From: Tim Screen
Sent: 04 August 2023 16:55
To: Linda Griffiths
Cc: Charlotte Watkins
Subject: RE: 22/03868/OUT

Having considered the developer's additional information as a result of Judith Ward's email of 27.02.2023, I respond as follows:

Tim Screen CMLI
Landscape Architect
Environmental Services
Environment & Place
Cherwell District Council

20 STREET TYPOLOGY & CHARACTER AREAS

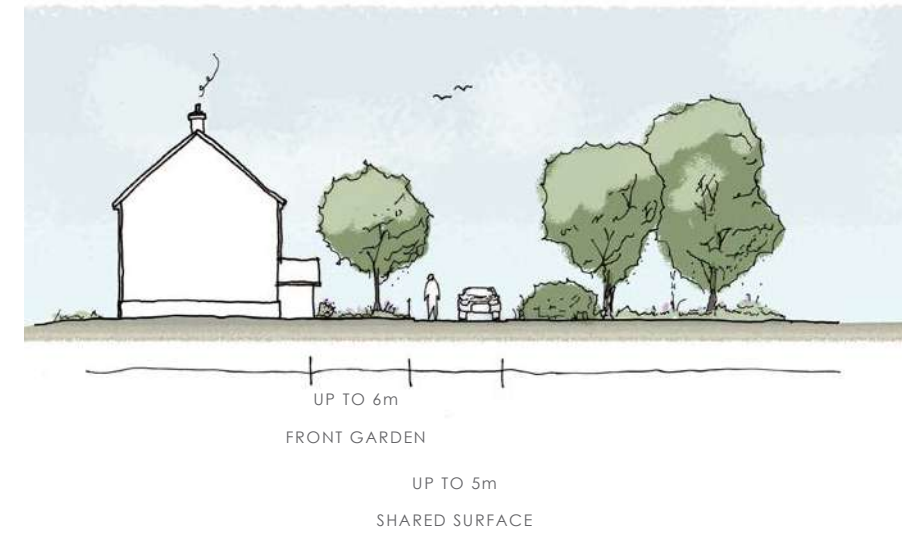
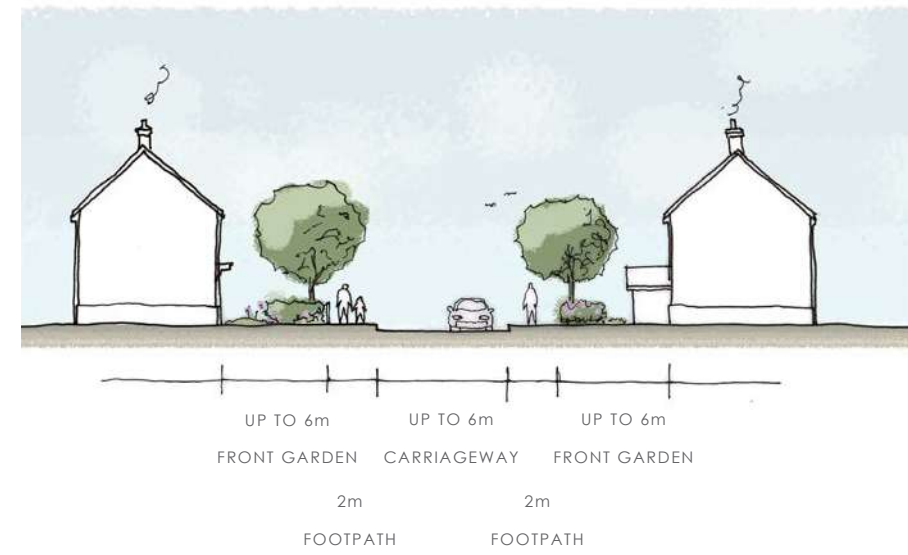
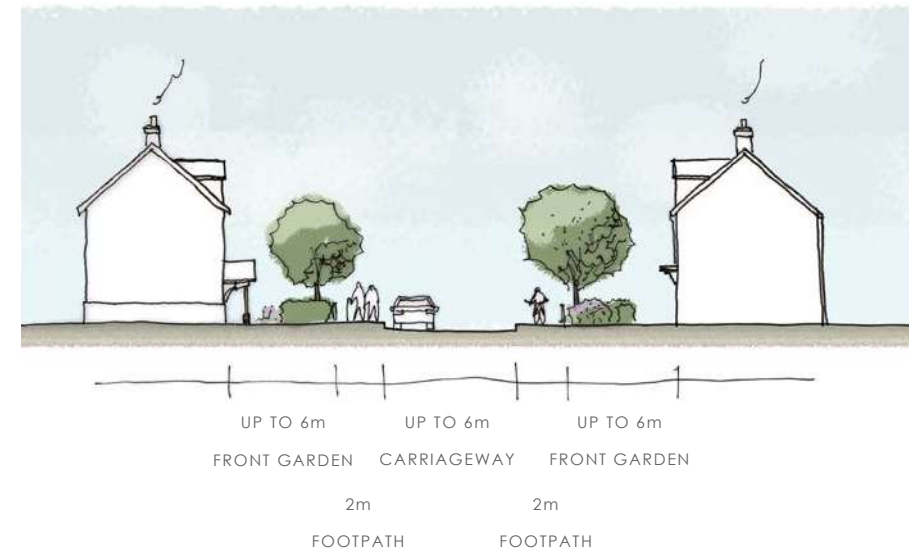
I refer you to the proposed cross-sections of the LS on page 16. I note that the verges are not wide enough to accommodate the trees. There should be at least 2 m between the edge/kerb of the pedestrian route and the stem of the tree. Ensure that a root deflector can be installed to prevent heave and structural damage caused by spreading tree roots. It is important to consider street trees. The 'right tree in the right place' is crucial for peri-urban GI and the benefit to the environment, visual amenity and wildlife. In this regard the landscape consultant should consider <https://www.tdag.org.uk/tree-species-selection-for-green-infrastructure.html> (Trees Design Action Group's tree species selection). OCC Highway should recognise the benefits of street trees and adopt them.
